Application No: EP/69/21/PL
Site Address: 4 Beechlands Close and east of 18 Beechlands Court Montpelier Road East
Preston BN16 1JZ
Description of works: 1 No. 3-bed bungalow (resubmission following EP/10/21/PL). This site is in CIL
Zone 4 & is CIL Liable as new dwelling.

Thank you for your internet representation made on 24th July 2021 which has been recorded as an objection with the comments as follows:

SITE PLAN

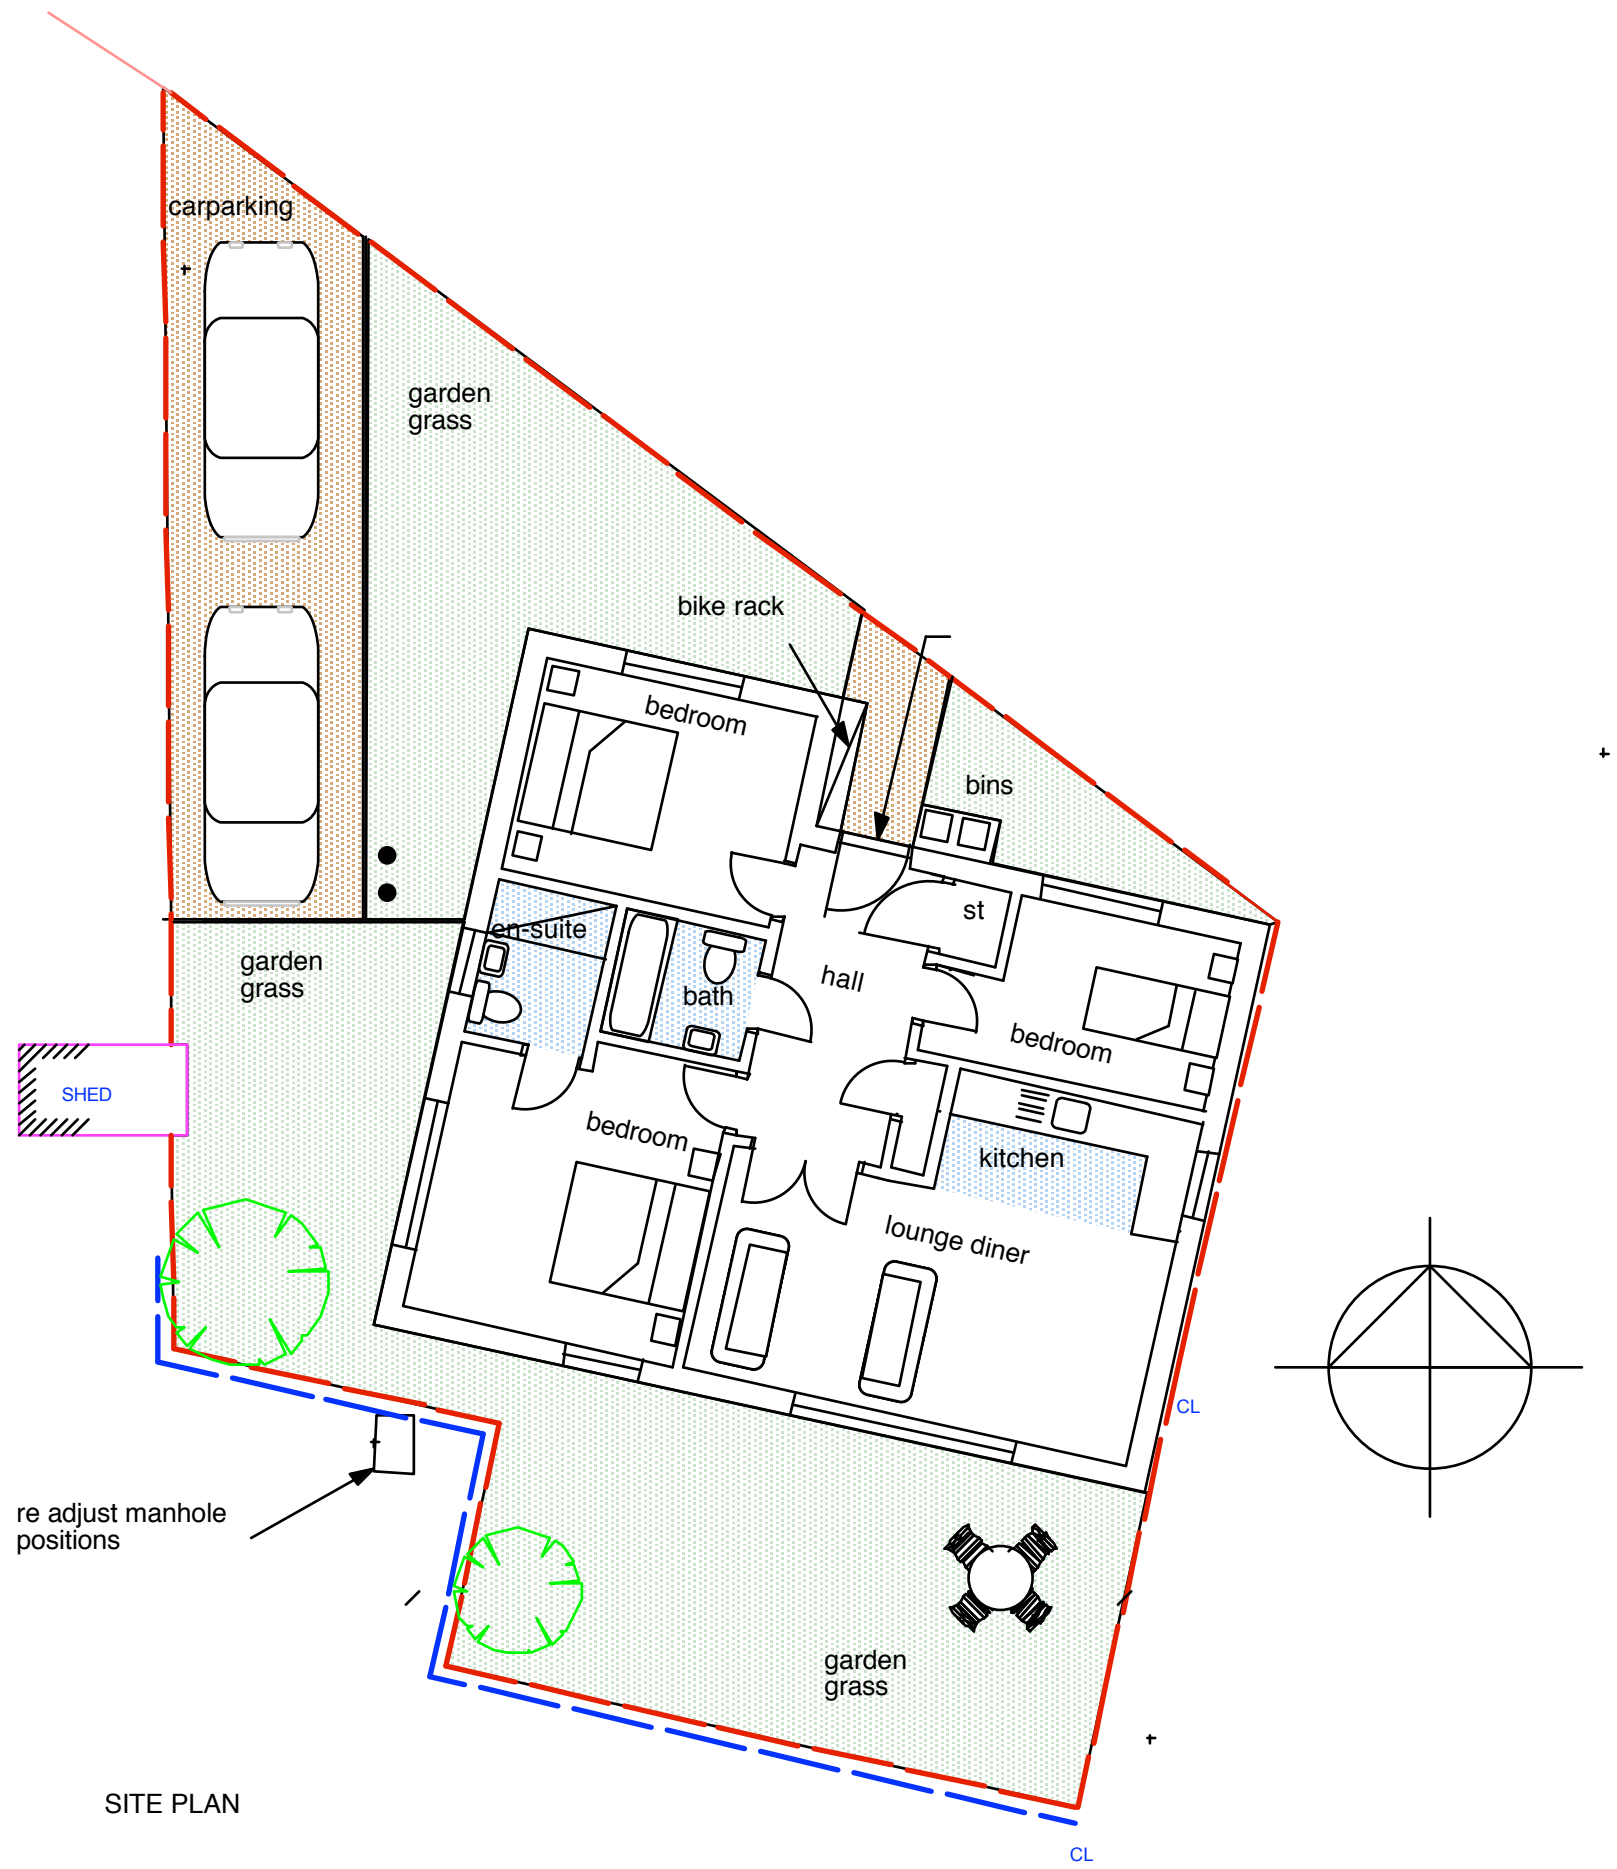
This application remains an overdevelopment of a very small site. The parking arrangement is inadequate for two cars and impractical for manoeuvring in and out. The crossover would be in a dangerous position for Beechlands Court residents driving from the garages and parking at the rear of the blocks. It would cause congestion on the road and reduce available on road parking which is already full.

Building on this site would have a negative impact on the open aspect of the neighbourhood, adversely affecting nature and hedgehogs' habitat in the immediate vicinity. Flat 18 would lose its parking space and garden. Given the events of the past 18 months it would seem to be a retrograde step to build on someone's only piece of outside space.
